From: [Svetlana Rodgers](#)
To: [Andrew Watson](#)
Cc: [Geoff Turnbull](#)
Subject: HPE CM: Re: Notice of Exhibition – Waterloo Metro Quarter OSD – Southern Precinct Detailed Design SSDA Modification (SSD-10437-Mod-2)
Date: Saturday, 9 September 2023 5:55:10 PM

Please find attached the notice of exhibition for the Waterloo Metro Quarter OSD – Southern Precinct Detailed Design SSDA Modification (SSD-10437-Mod-2).

**Figure 28 |** Overshadowing analysis on Alexandria Park showing impact caused from Central and Southern Precinct buildings at 9:30am in midwinter (Source: Applicant's EIS)

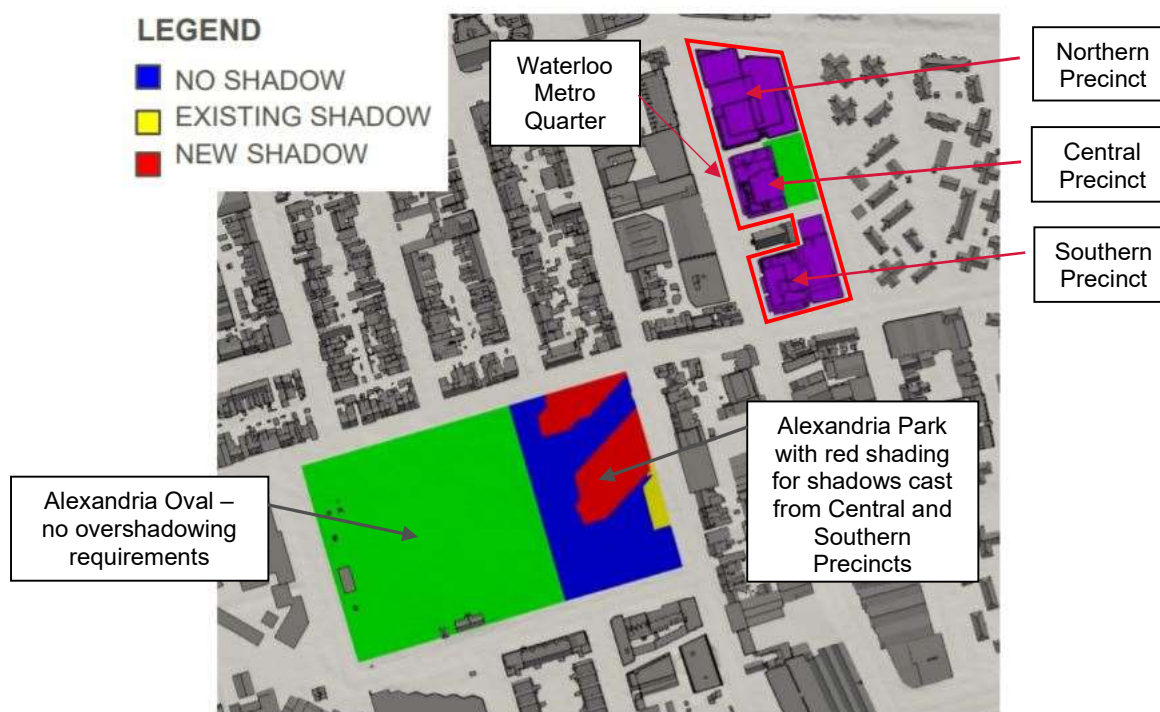
Why are the new height increases are considered for overshadowing the Alexandria park, which is very brief in the morning, rather than the impact on the newly created park in Waterloo Central next to the Metro Quater, which is much more dramatic and important for future residents?
